Consultation Response from KC, Highways Development Management
2024/92590 36, Syringa Street, Marsh, Huddersfield, HD1 4PD
Erection of extension to rear, refurbishment of basement with steps to front, formation of driveway and drop kerb
Date Responded: 21-11-2024. Responding Officer: Mark Berry. Responding Ref: 5-2SE-64.

Proposed Ground Floor Plan Scale 1:100

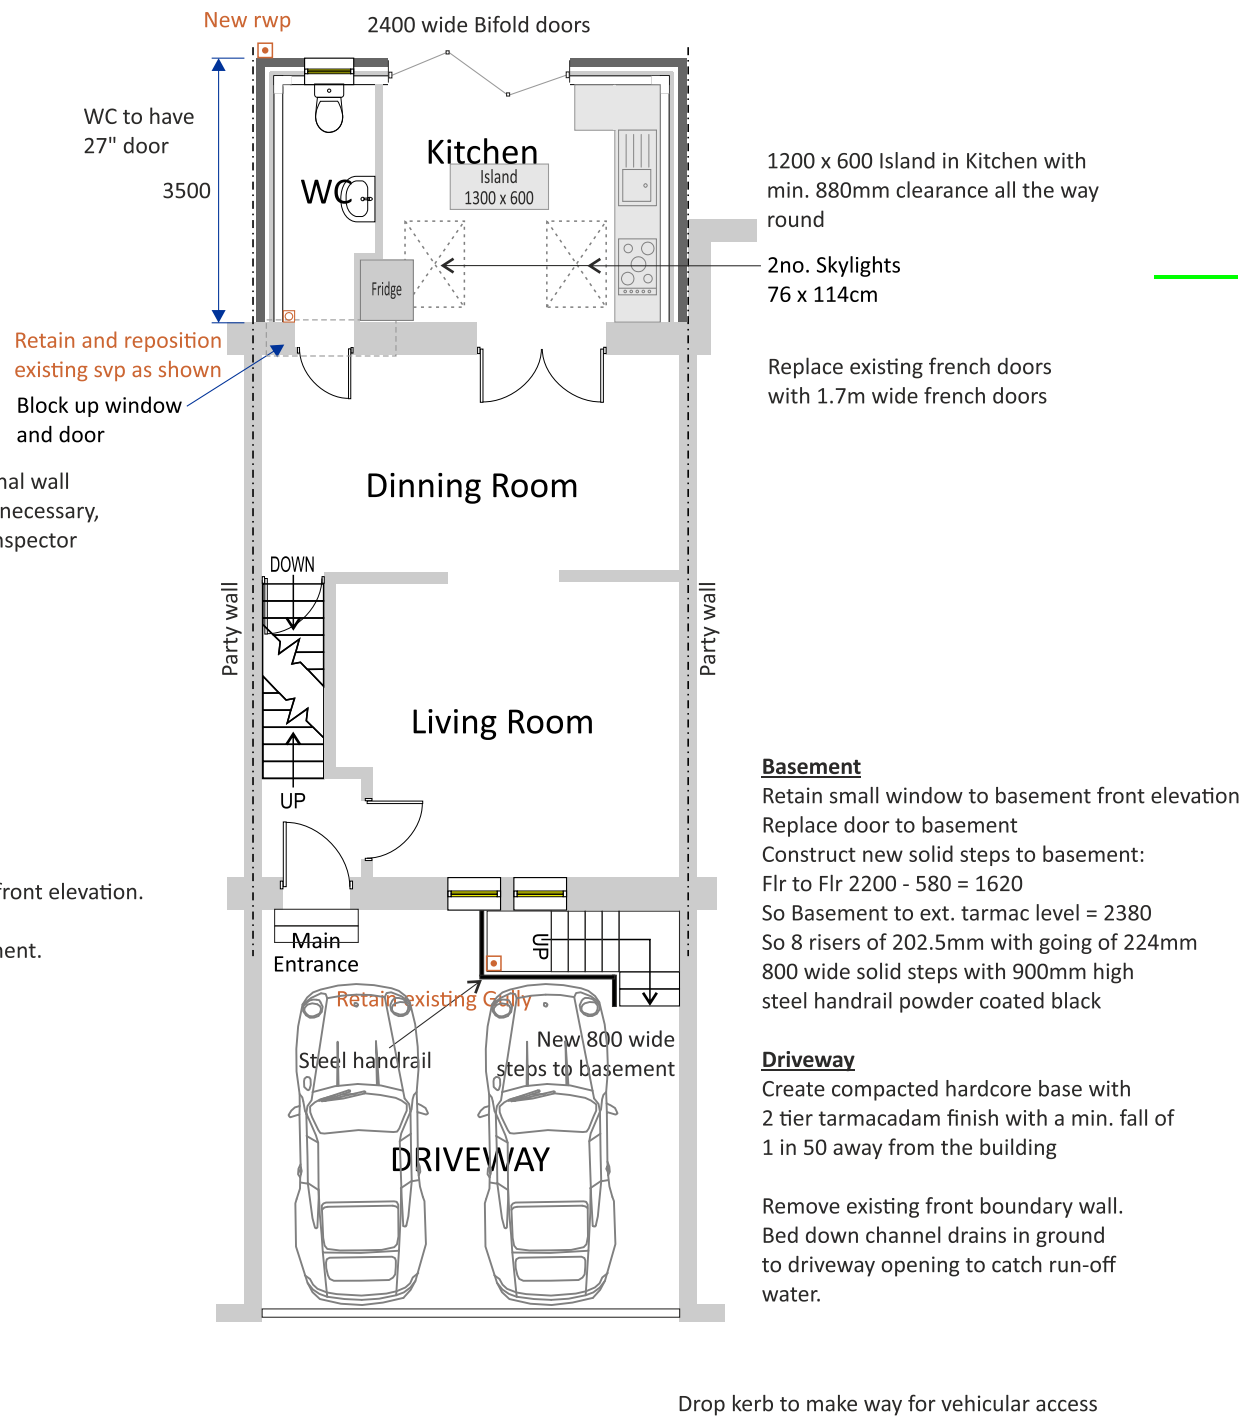
These proposals include the provision of 2 parking spaces to the front of the dwelling with access onto Syringa Street.

These parking spaces scale 4.6m in width x 4.4m in length. These dimensions do not meet the recommended minimum dimensions of 4.8m x 5.0m and in any case the proposals leave insufficient space for pedestrian access to the dwelling.

This proposal will result in vehicles over hanging the footway along Syringa Street which would not be in the best interests of highway safety.

On-street parking along this section of Syringa Street will result in poor sight lines from the proposed parking spaces onto Syringa Street.

Intervisibility between pedestrians and vehicles exiting the proposed parking spaces could be poor because of the height of the adjacent boundaries.

HDM would recommend that the proposed parking is removed, or this application should be refused on highway safety grounds.
